RE: HORIZON AT LEE 5 SSD-9827, 45 HONEYSUCKLE DRIVE (LOT 5 DP 1238761)

We are pleased to submit this Section 4.55(1A) application on behalf of Horizon Newcastle Pty Ltd. This application seeks consent for minor design amendments and changes to conditions of consent that have been identified as necessary during the ongoing detailed design in the lead up to the construction certificate phase to the Mixed Use Development approved under SSD-9827.

Plans
Typical Floor Plan (L1-6)

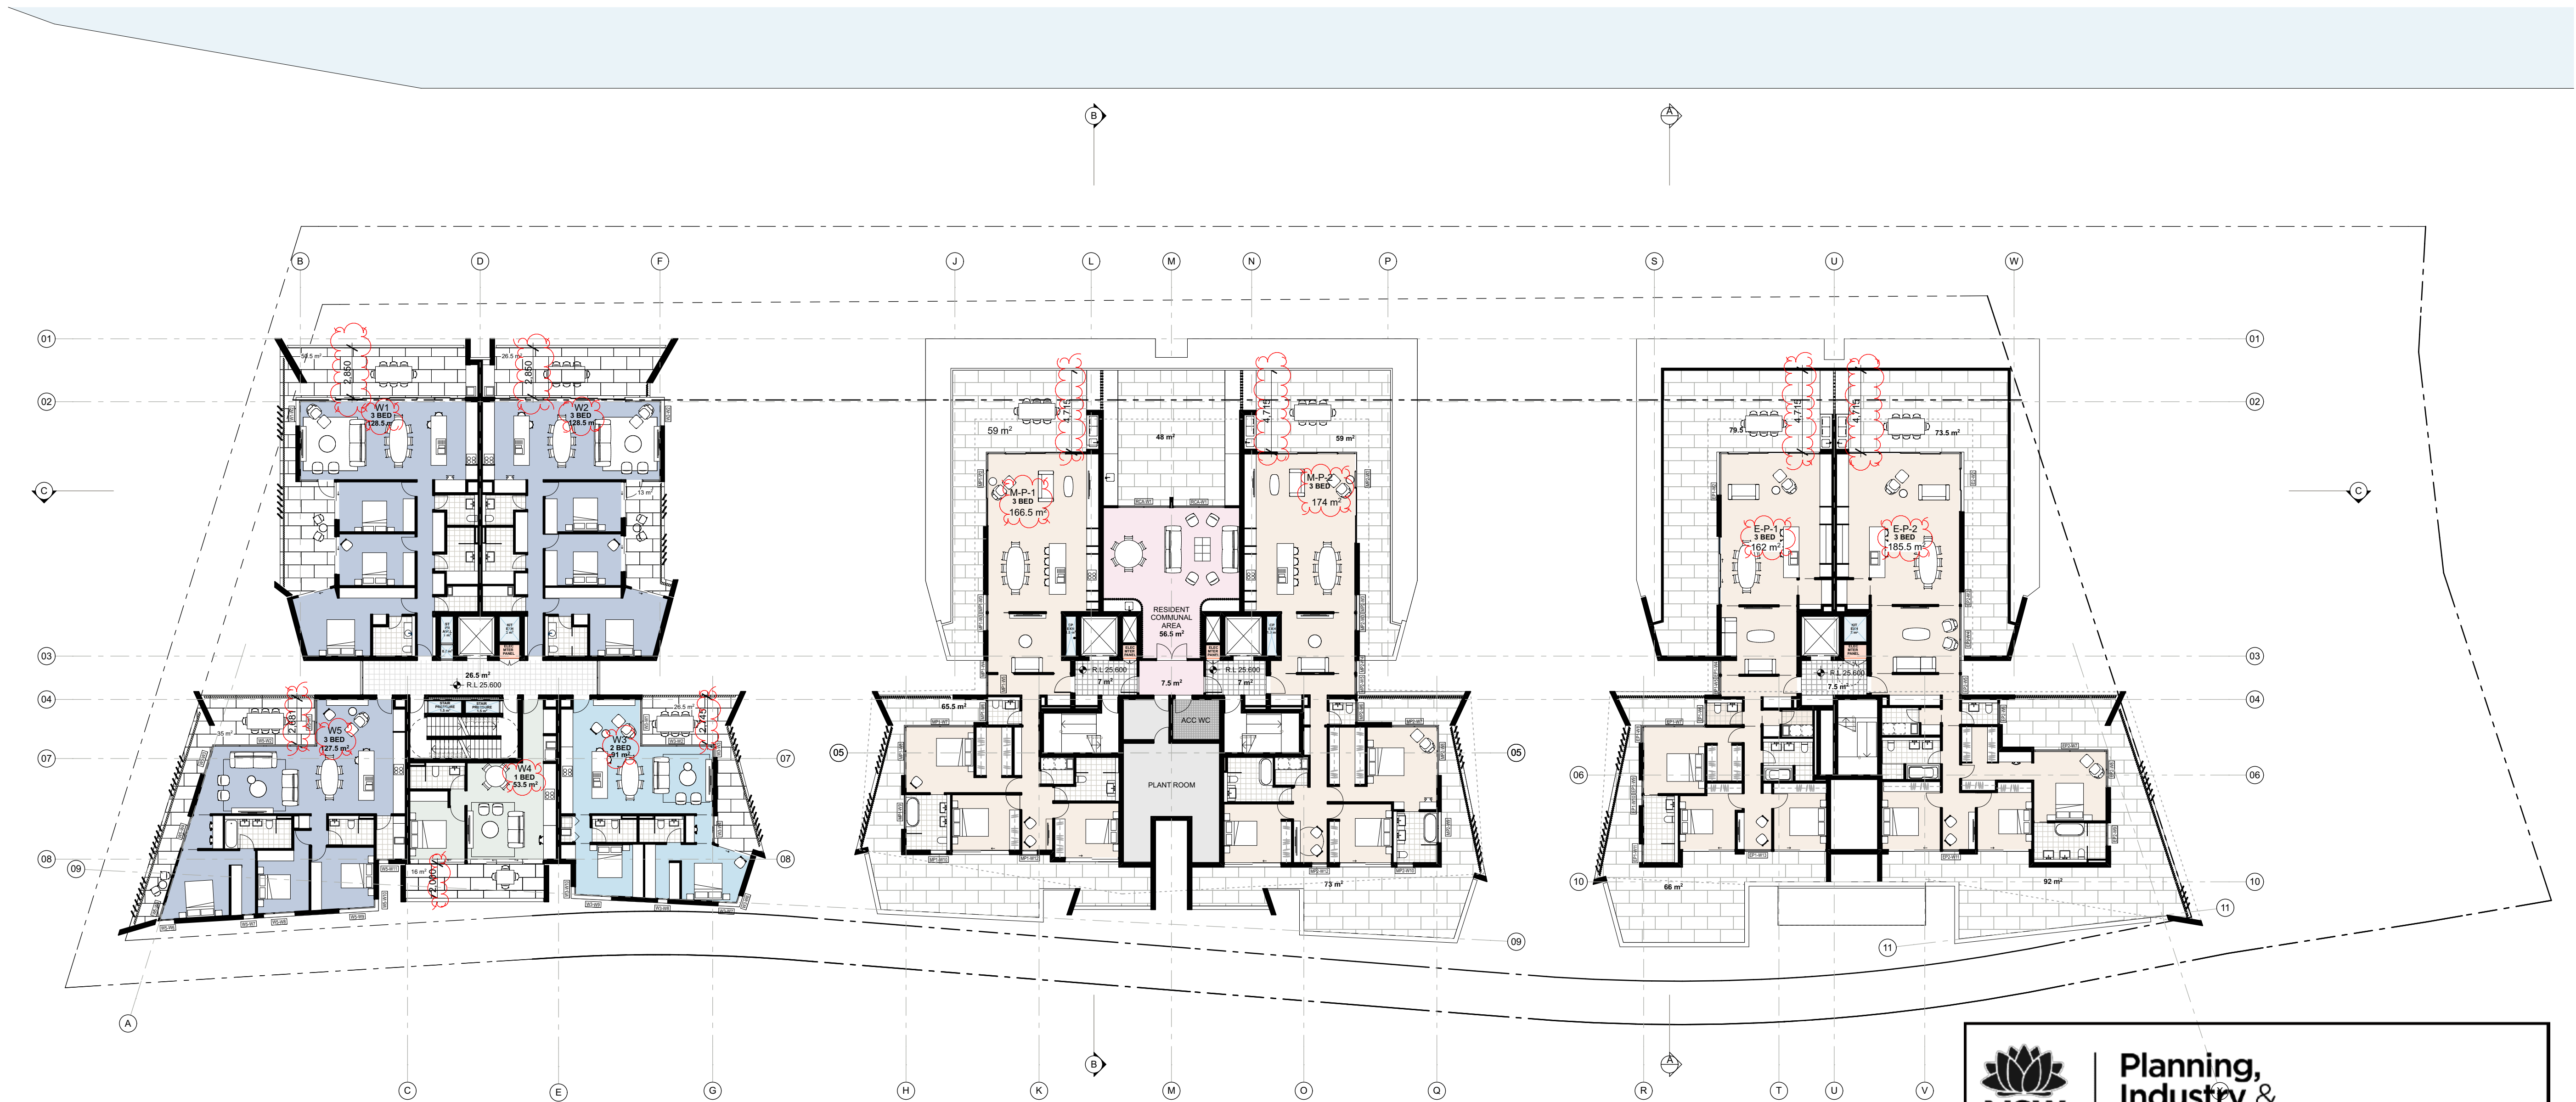
- Design rationalisation and minor changes to the two (2) bedroom units on Levels 1 to 6 in both the central and eastern building.
- Design changes to Unit Type 1 as a result of the internal reconfiguration in terms of the position and alignment of the stairwell.
- Internal design changes to Unit Type O.
- The void in the centre of the middle building on the southern elevation between Units M5 and M6 has been filled as a result of a design rationalisation to the buildings core. This will result in a slight increase to the area of the balconies for these units.
- A 6m² reduction in size to Units M1 and M2. A 1m² reduction in size to Units E4.

Unit Type Q
SCALE 1:100 @ A1

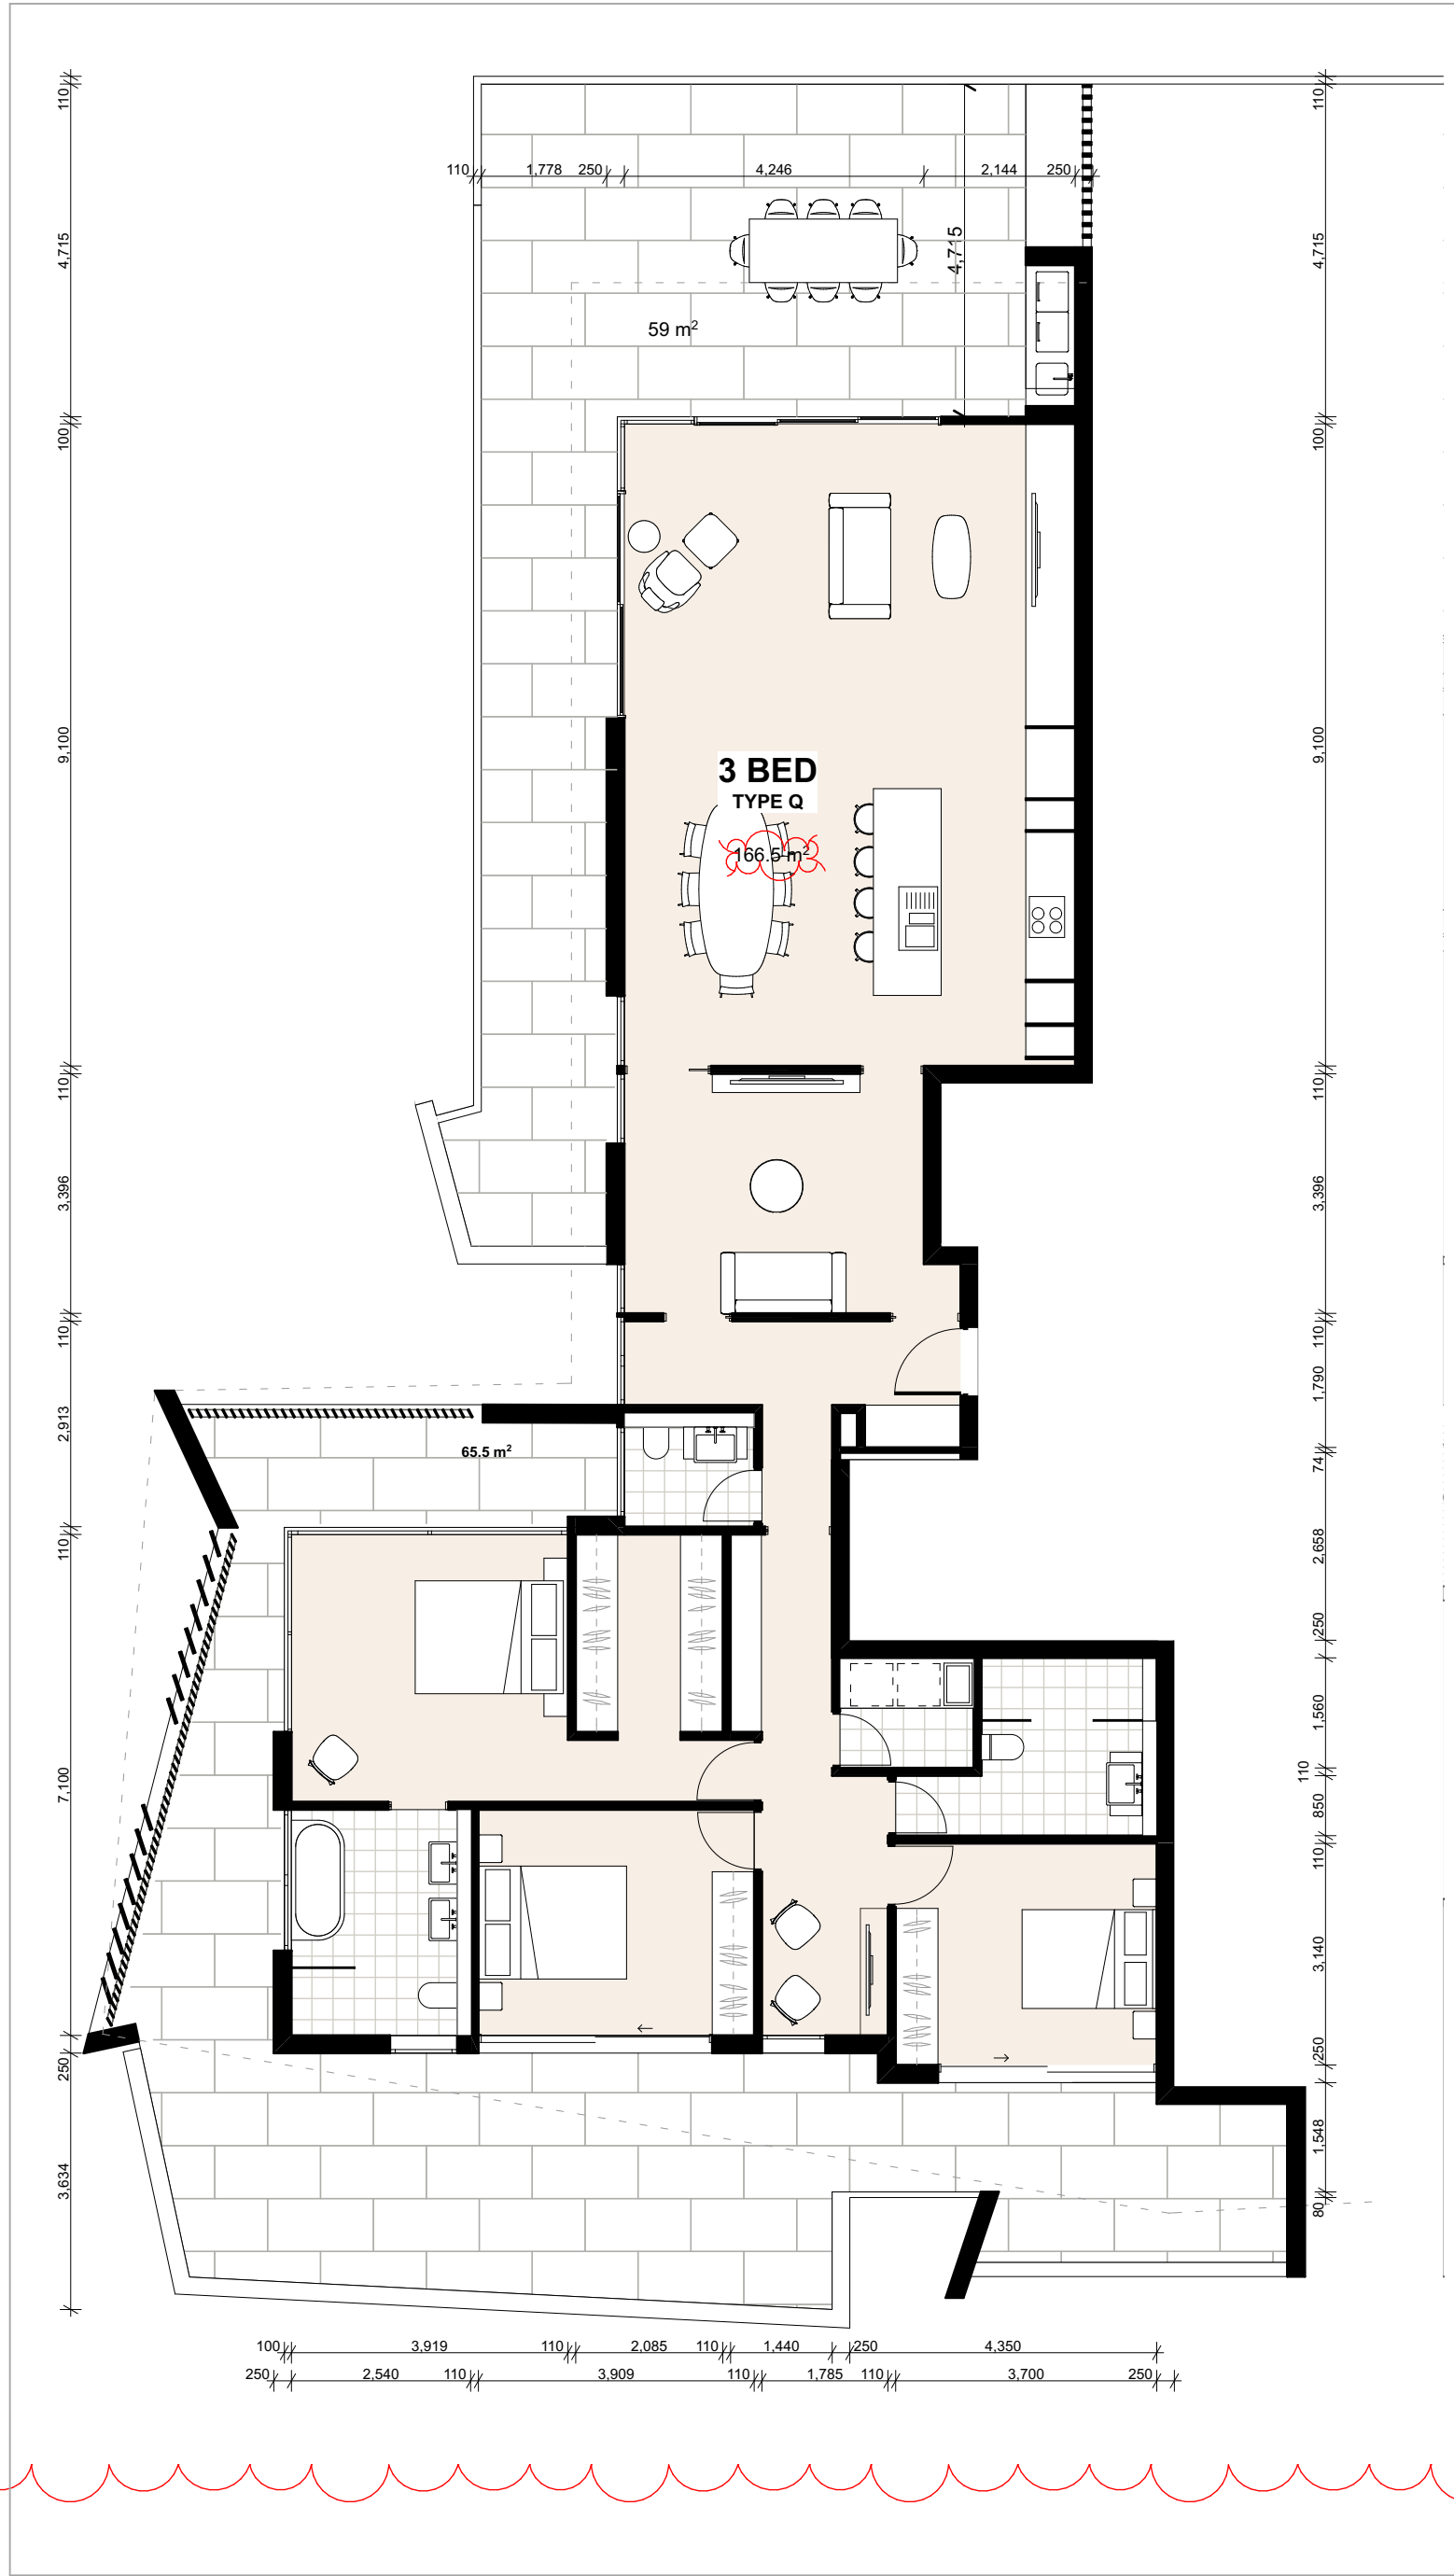
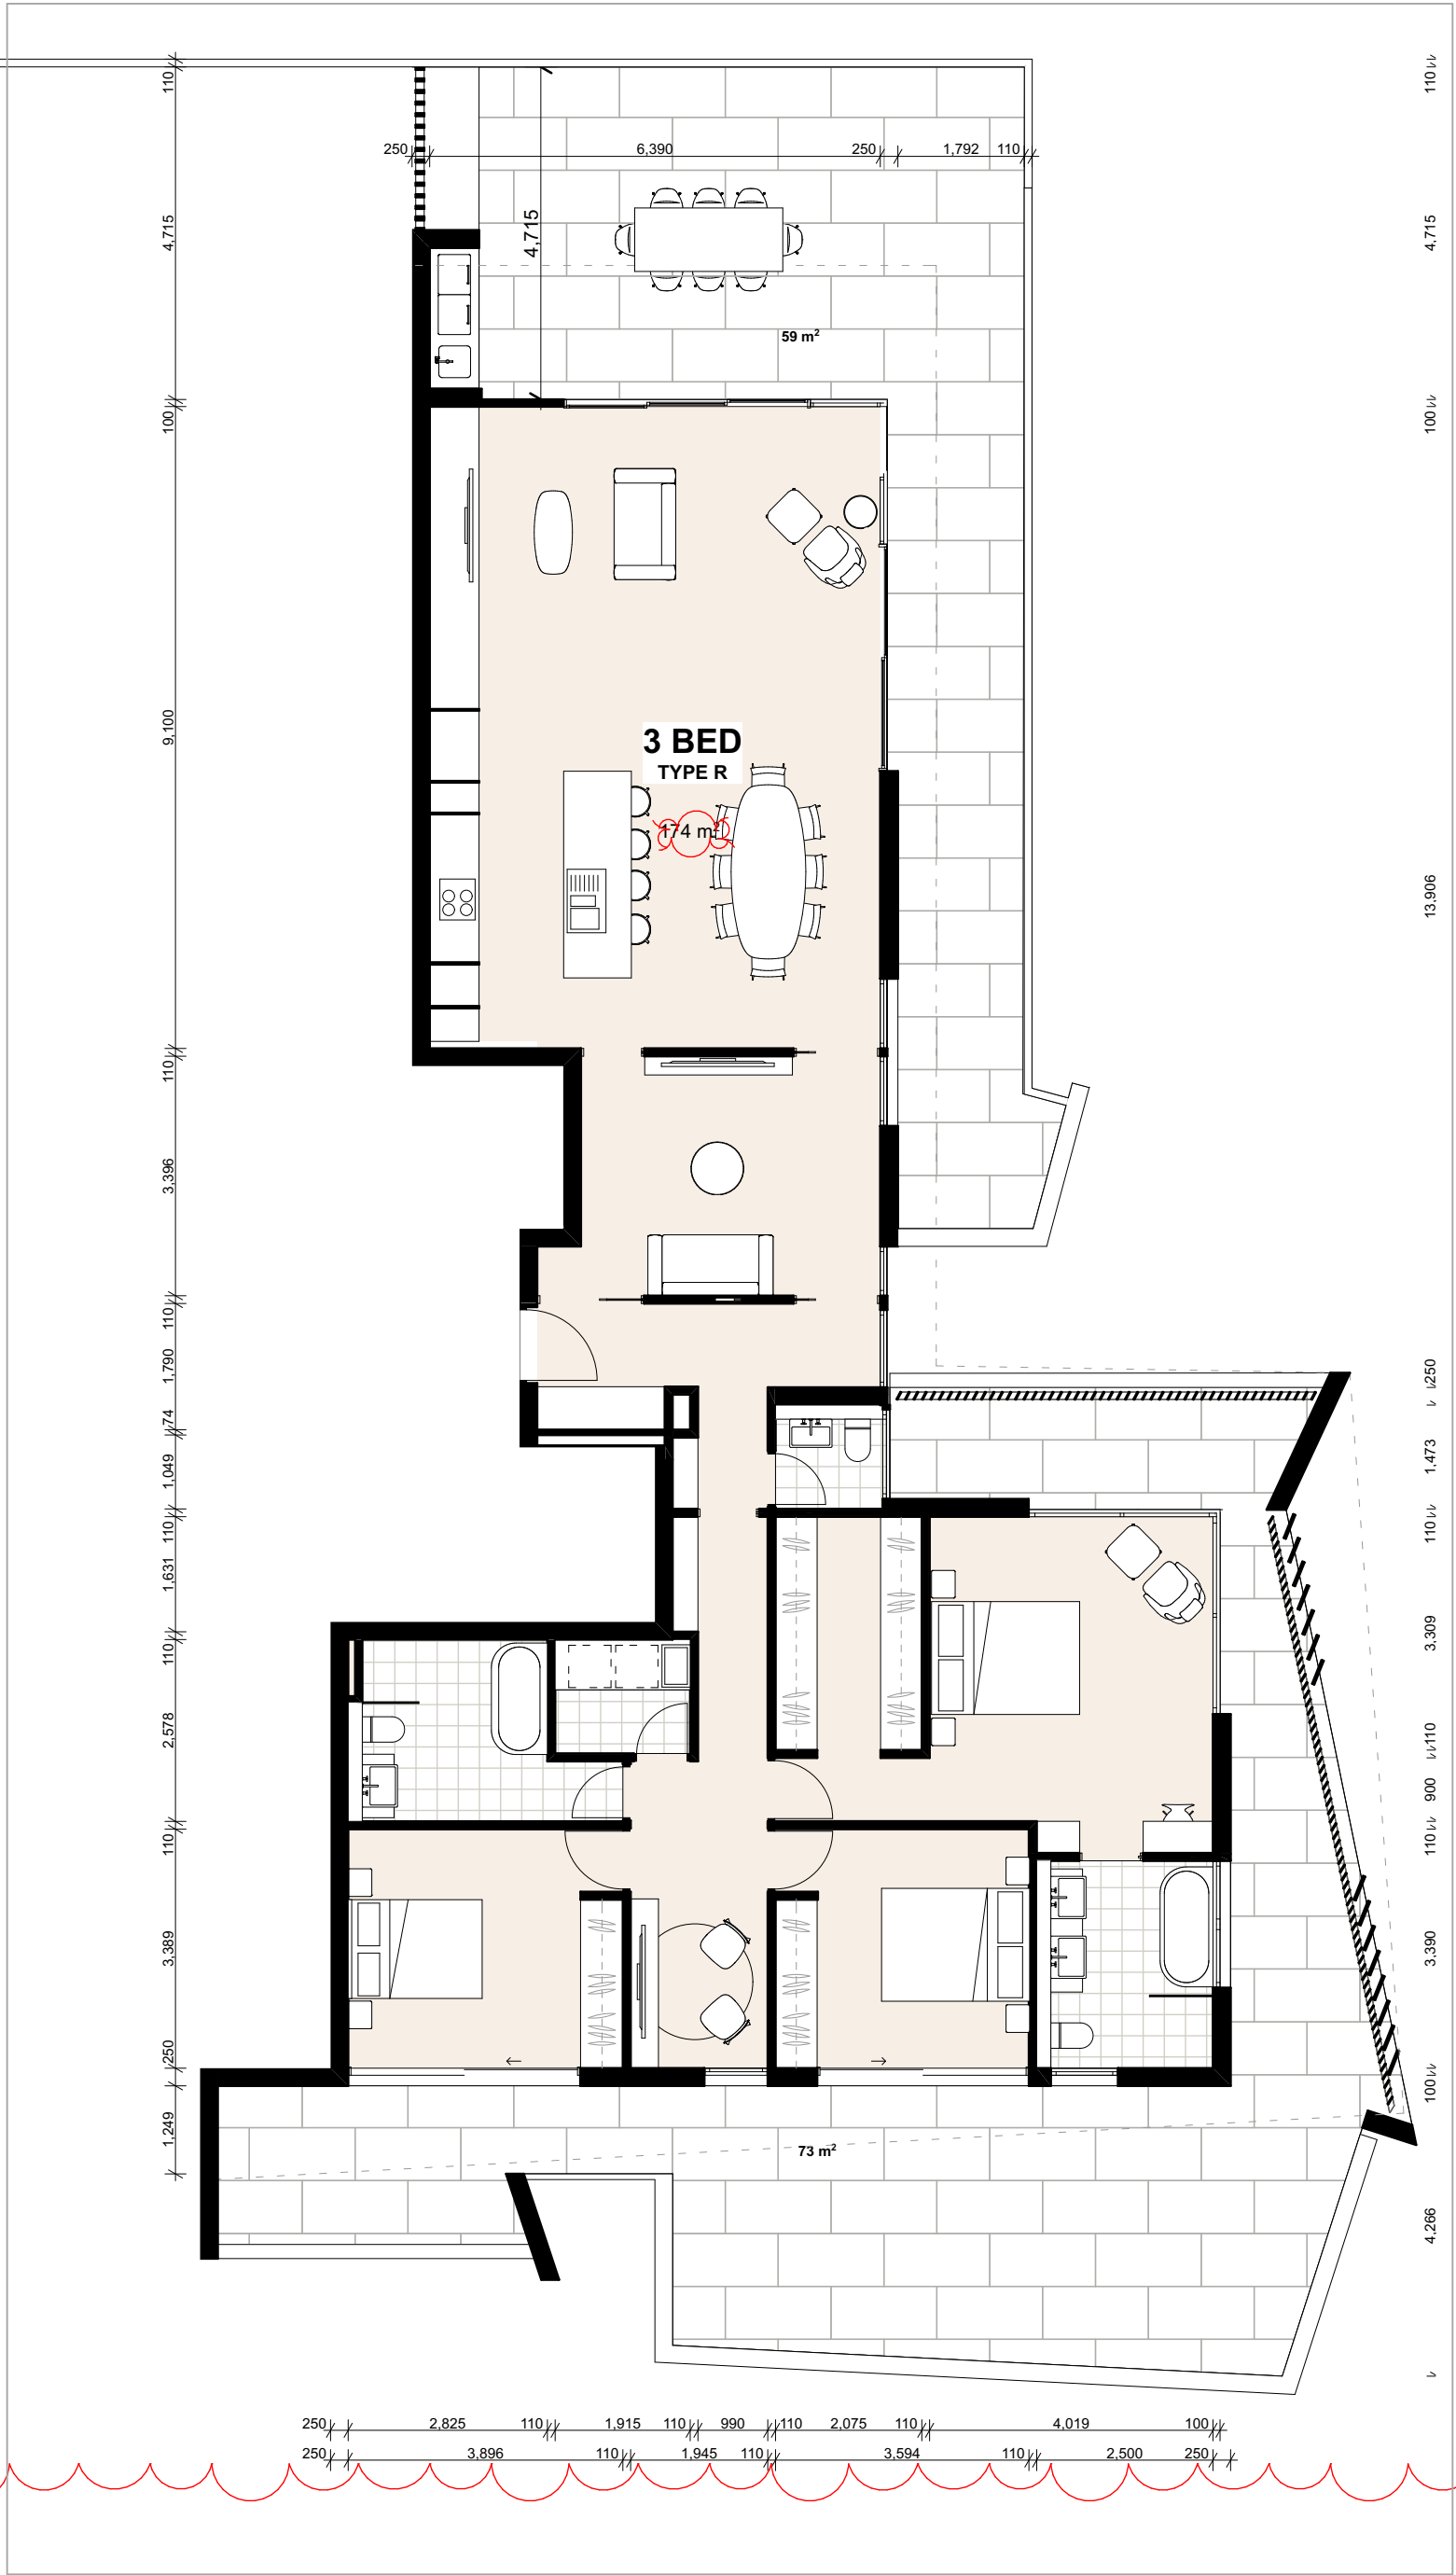
- As a result of the changes described above, these changes have been reflected in the Unit Types Q, R, S and T.
